PROJECT NO. PR-2018-001579

SI-2021-00304 SITE PLAN, SI-2021-00305 SITE PLAN AMENDMENT
PS-2021-00040 SUMMARY PLAT (PLAT OF EASEMENTS)

October 1, 2021

RE: PR-2018-001579 – WINROCK TOWN CENTER, SI-2021-00304 SITE PLAN, SI-2021-00305 SITE PLAN AMENDMENT, SUMMARY PLAT (PLAT OF EASEMENTS ONLY)

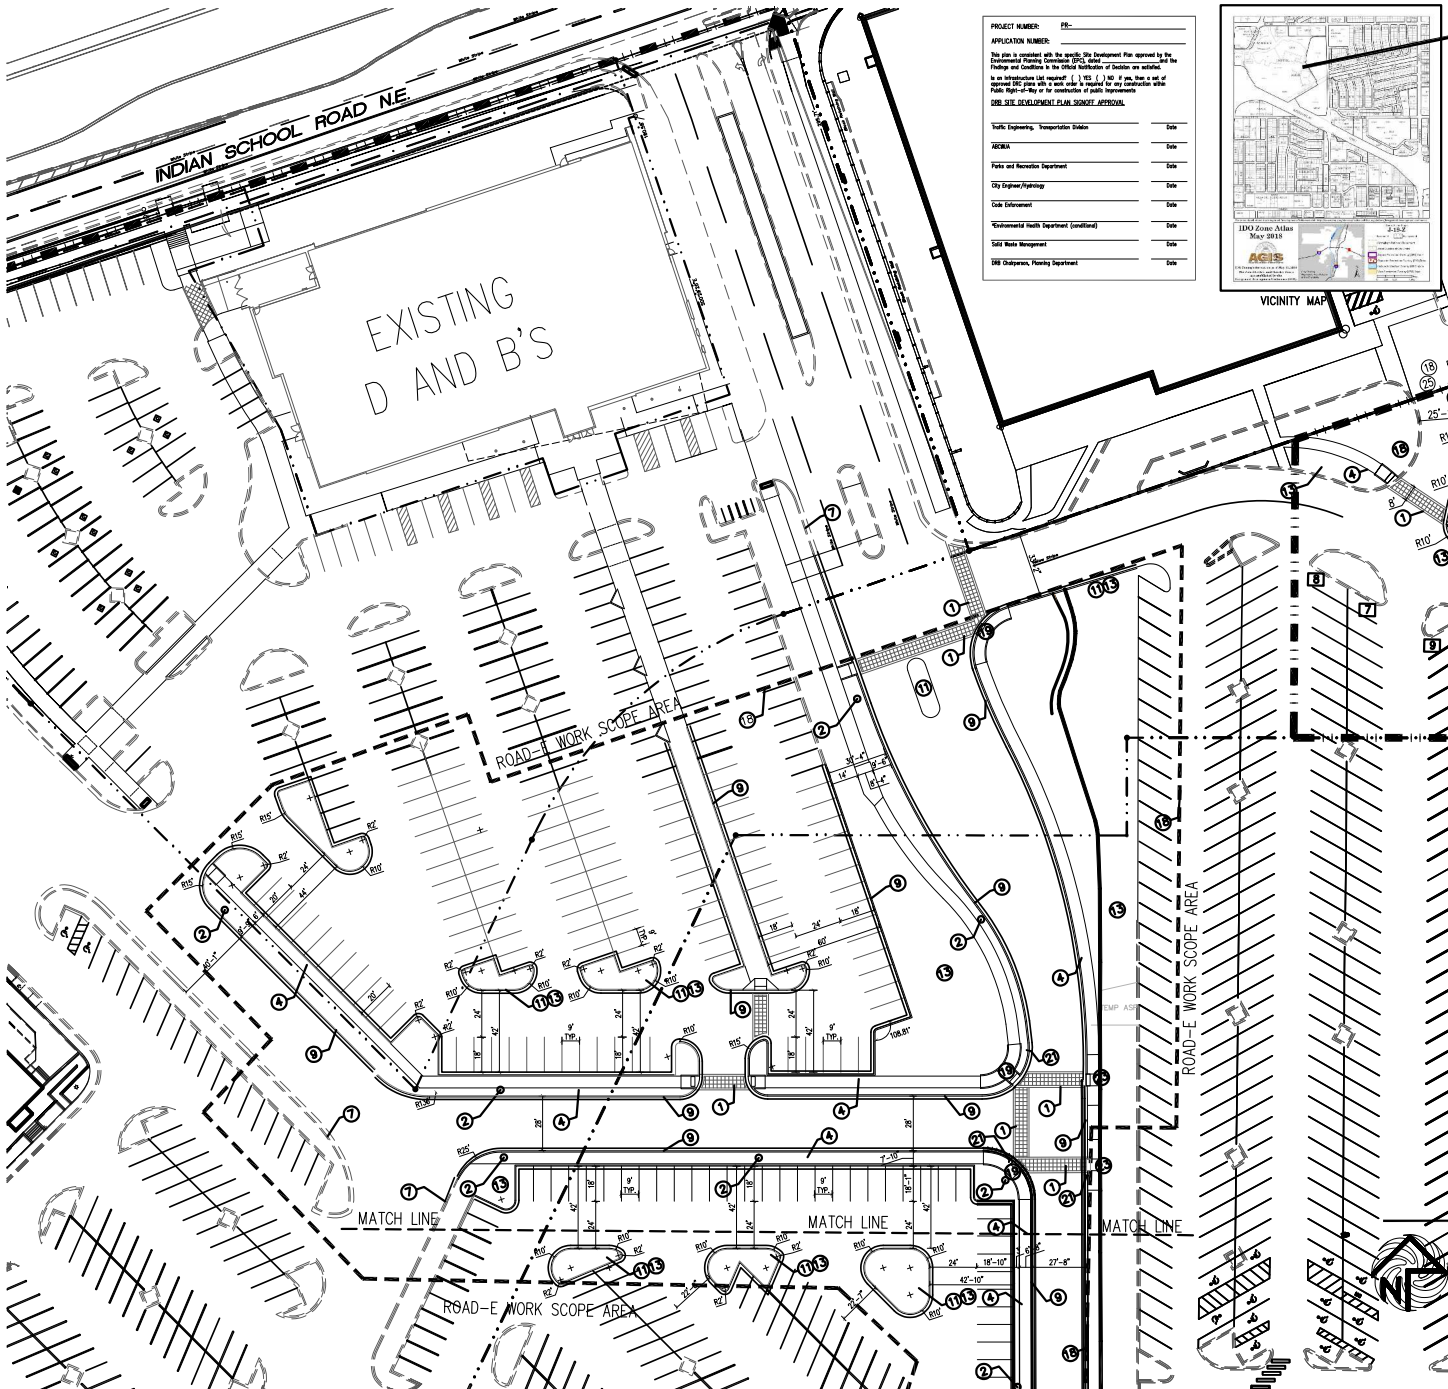
5. Provide proposed traffic control at intersection at the southwest corner and indicate any stop signage and pedestrian signage. Also label all other signage such as handicapped signage and motorcycle signage on the site plan. **Applicant Response: A site specific plan for Roadway E has been submitted with this application.**

9. Label all new curb ramps on the site plan and reference details. Delete any keyed notes that are not
10. being used regarding the ramps. On the northwest corner, indicate an adequate turning area at the top of the curb ramp and provide dimensions. **Applicant Response: One ramp style is being proposed at three locations, reference details have been included on sheet SP-1A.**

11. Indicate “No Parking” at the back of van accessible aisles. **Applicant Response: Notations have been added on sheet SP-1A**

**DRB EASEMENT EXHIBIT  
WINROCK CENTER ADDITION**

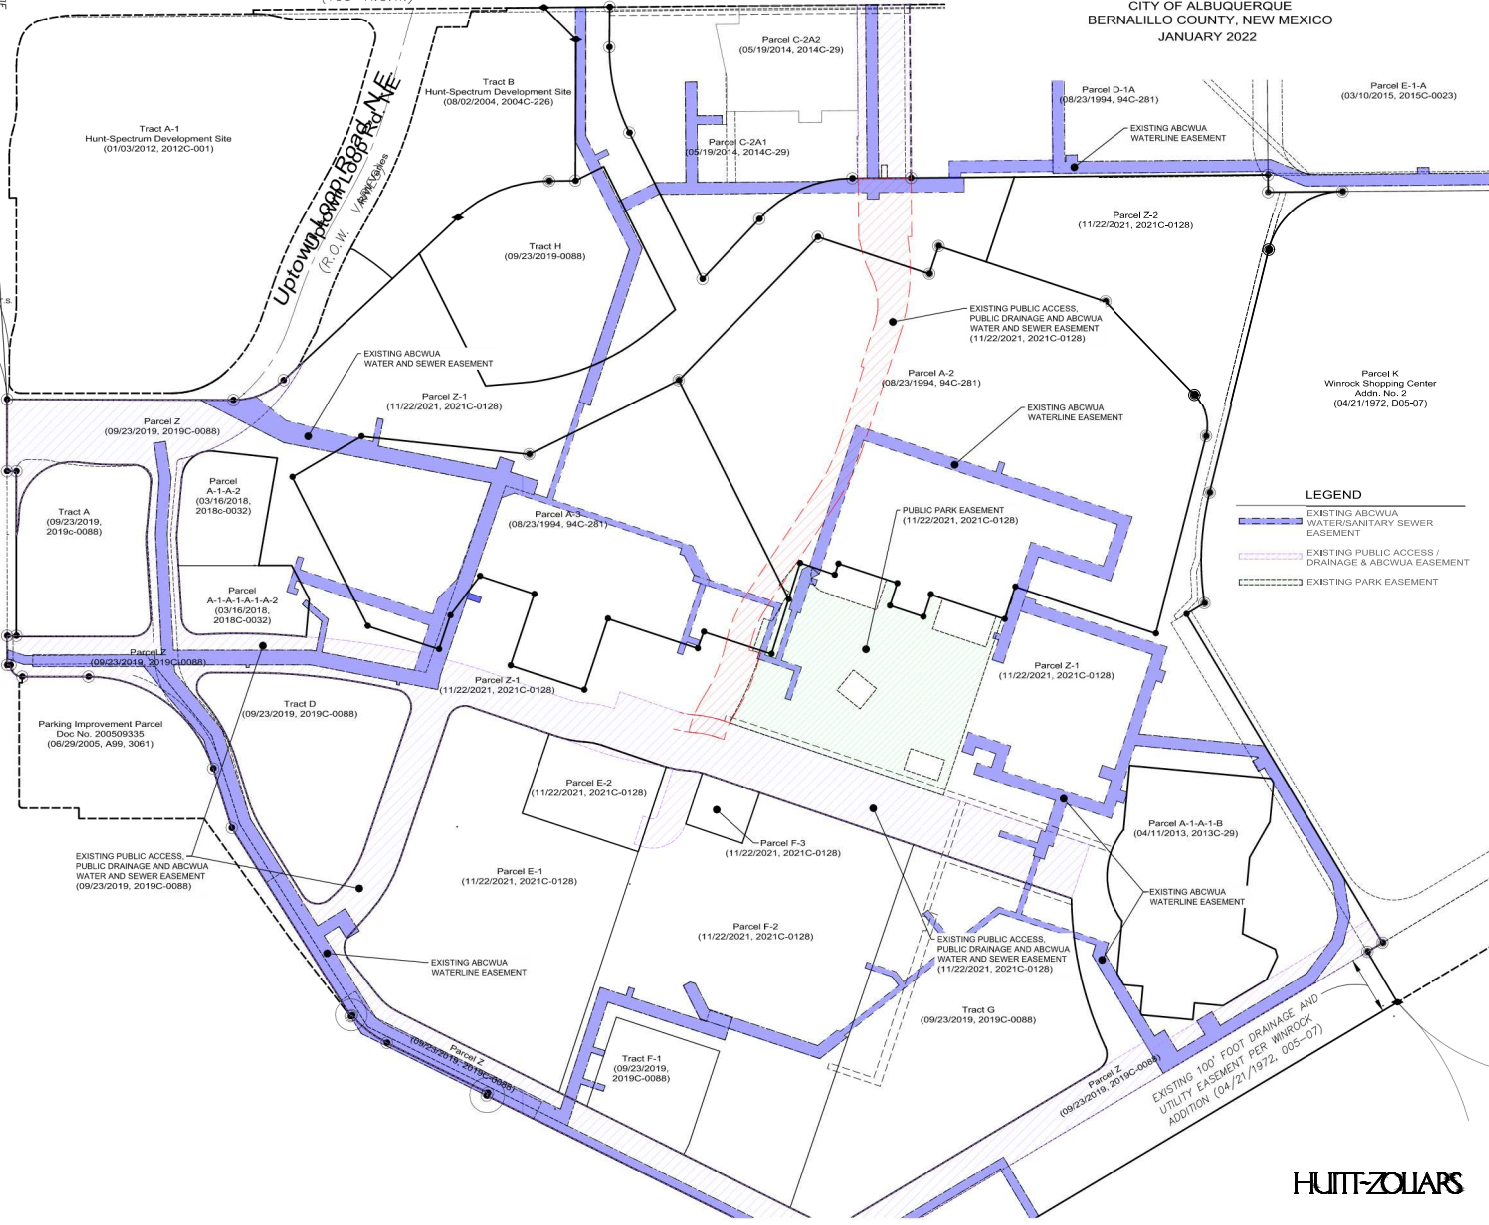
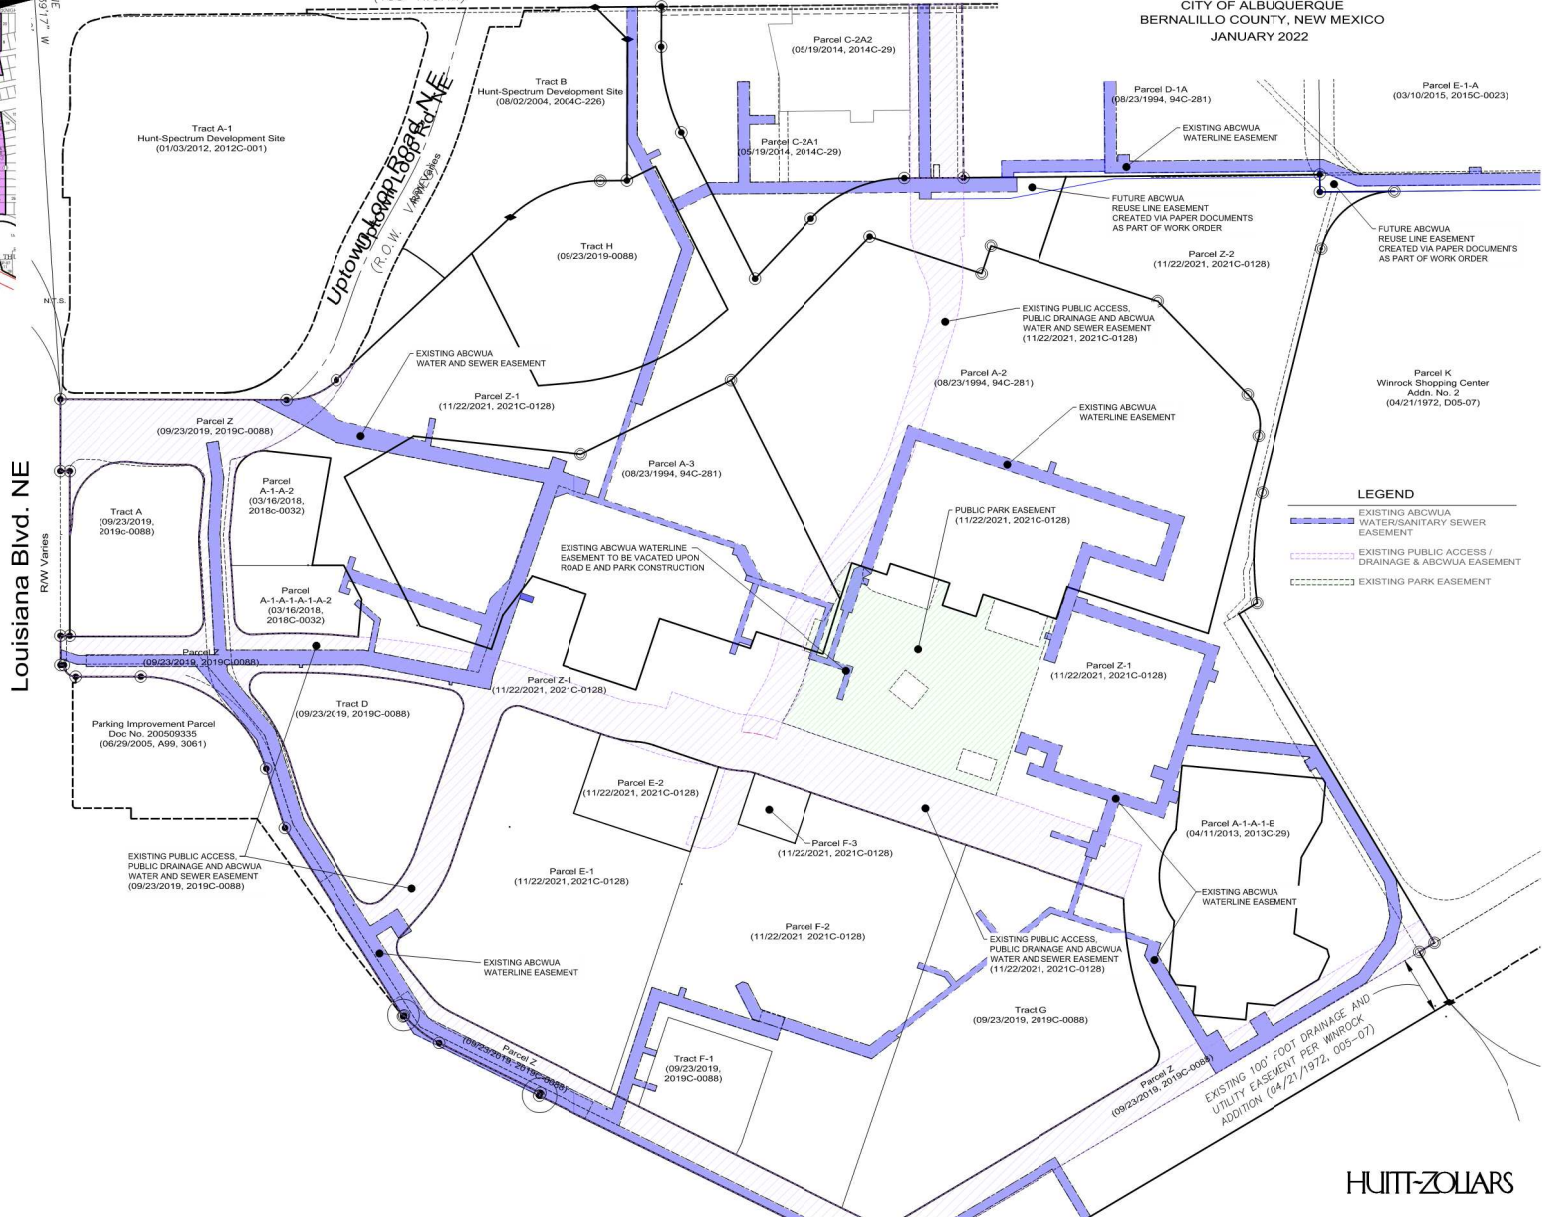
- viii. Please demonstrate sufficient easements for the proposed reuse lines, and any other public water and public sewer lines not currently within easements. The easement map provided with the plat does not appear to show easements for all the public lines, in particular the reuse running through the park and the initial sewer connection to existing manhole. **Applicant Response: Additional Easement Exhibit shall be provided.**

- viii. Please demonstrate sufficient easements for the proposed reuse lines, and any other public water and public sewer lines not currently within easements. The easement map provided with the plat does not appear to show easements for all the public lines, in particular the reuse running through the park and the initial sewer connection to existing manhole.
